PRESERVATION BOARD

Re: Rebuilding Stone Retaining Wall – 15 Vaughan Street

This office has reviewed and approved your proposal, submitted on your behalf by Mike Mercier on July 15, 2018, to rebuild the stone retaining wall along the sidewalk in front of 15 Vaughan Street.

Stone Wall 1 & 2 Detail (NTS)

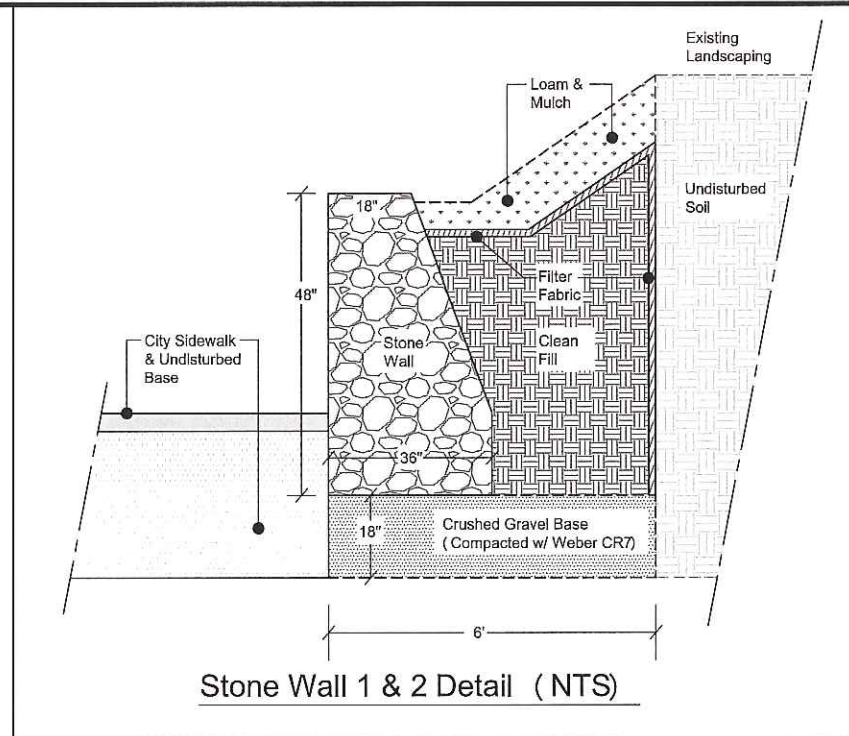
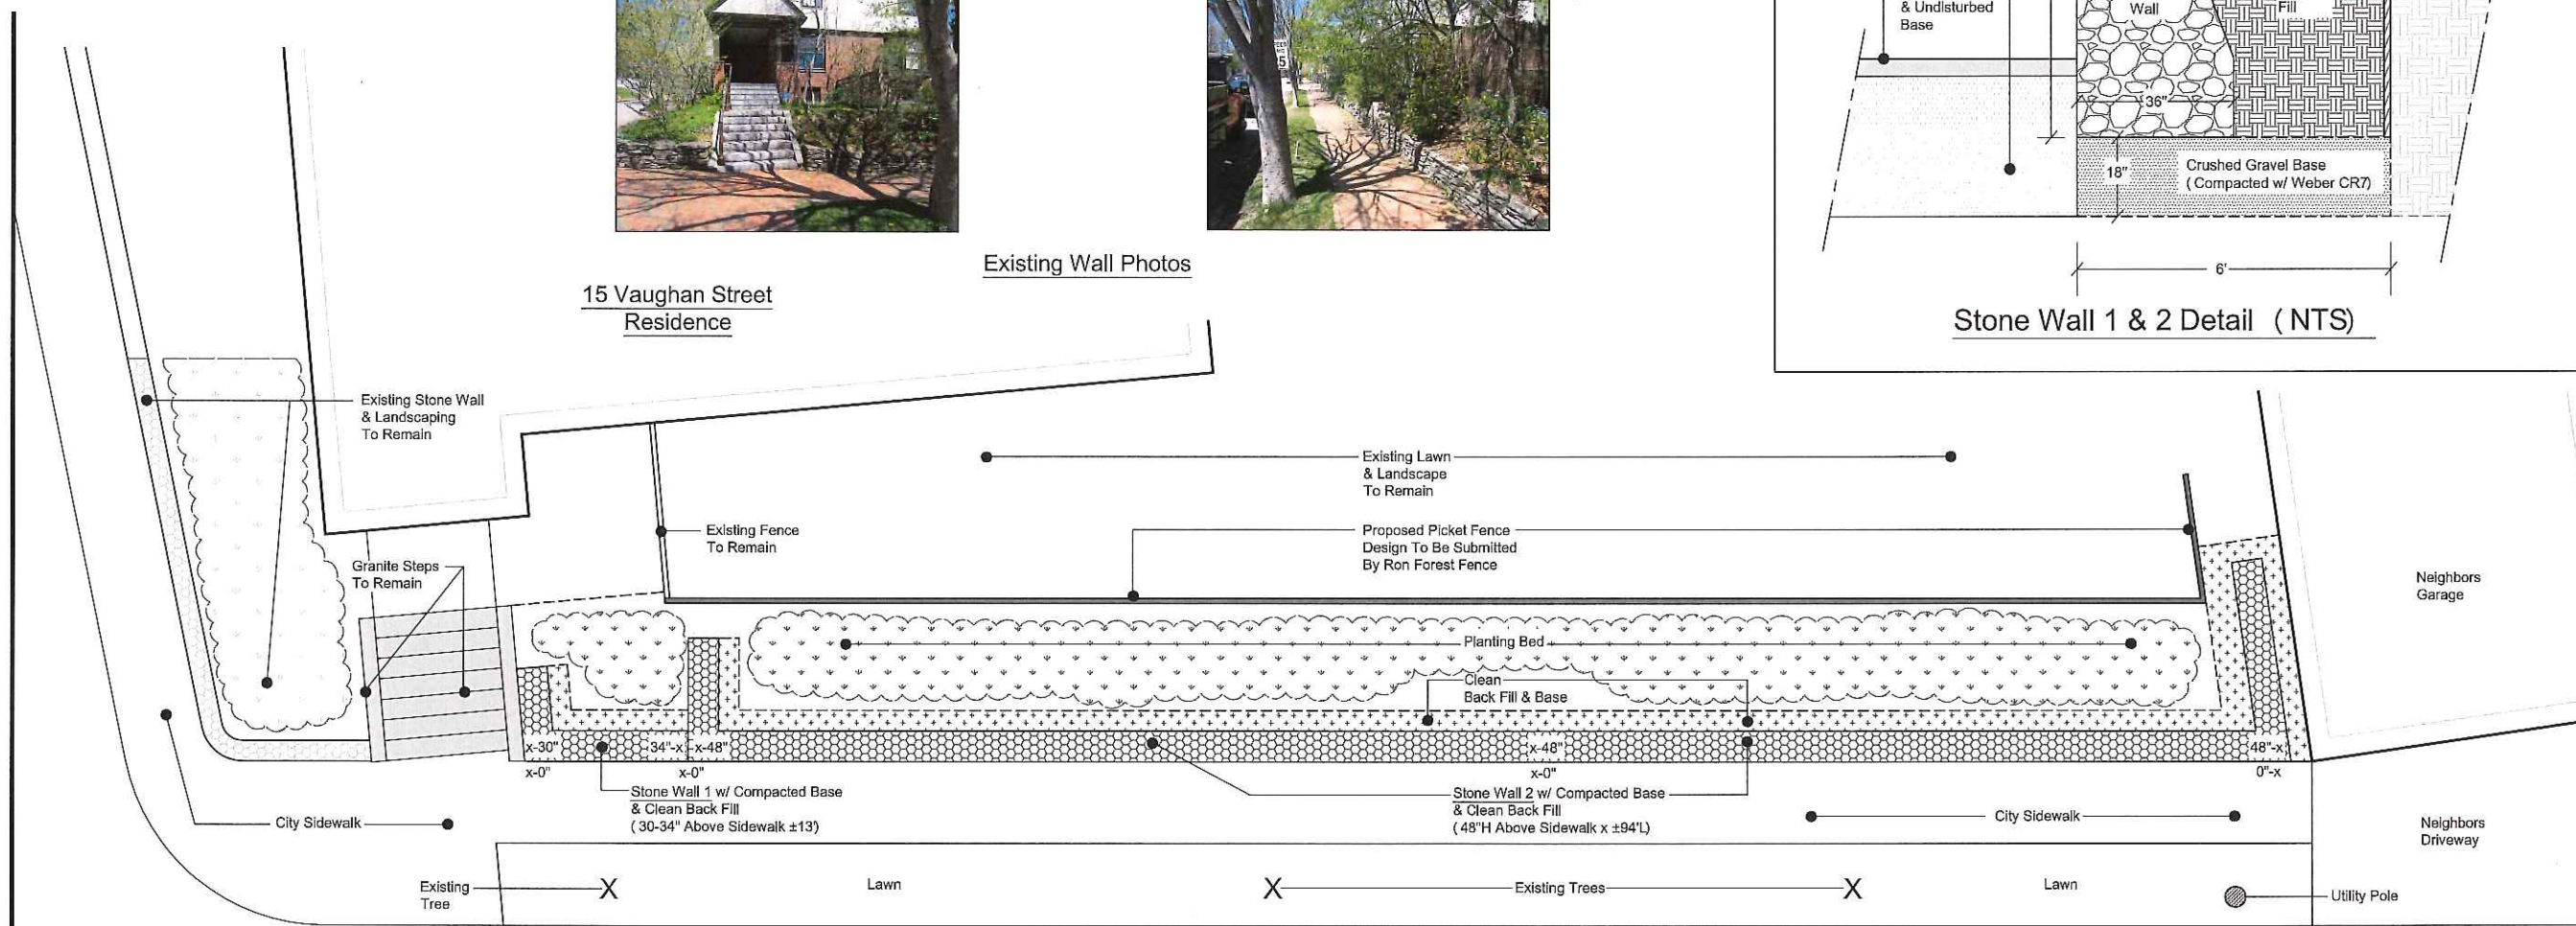
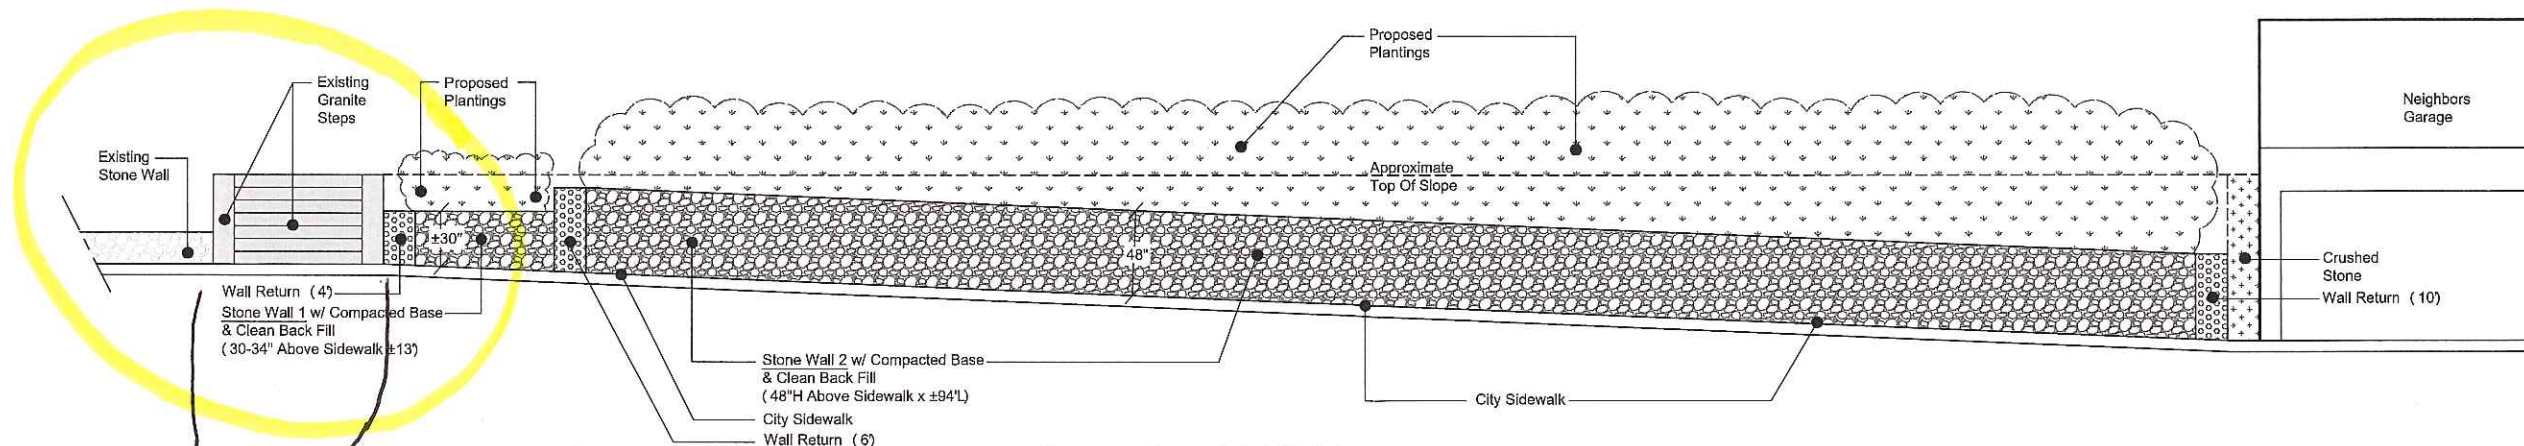
- The approved plan is the revision dated 6-22-18, except as amended by staff's conditions of approval.
- If the retaining wall is greater than 48" high from bottom of footing (including below grade portion) to top of wall, a building permit will be required.
- The new stone wall to the right (as viewed from Vaughan Street) of the granite stairs is to be the same height as the existing wall to the left of stairs - i.e. even with the same step. (See photo marked up by HP staff.)
- The finish and appearance of the new stone wall are to match the existing wall, except for differences in design and height.
- This permit approves the site plan and the plans for the stone wall. Fencing is to be reviewed and approved separately by the Historic Preservation Office, prior to ordering fencing.
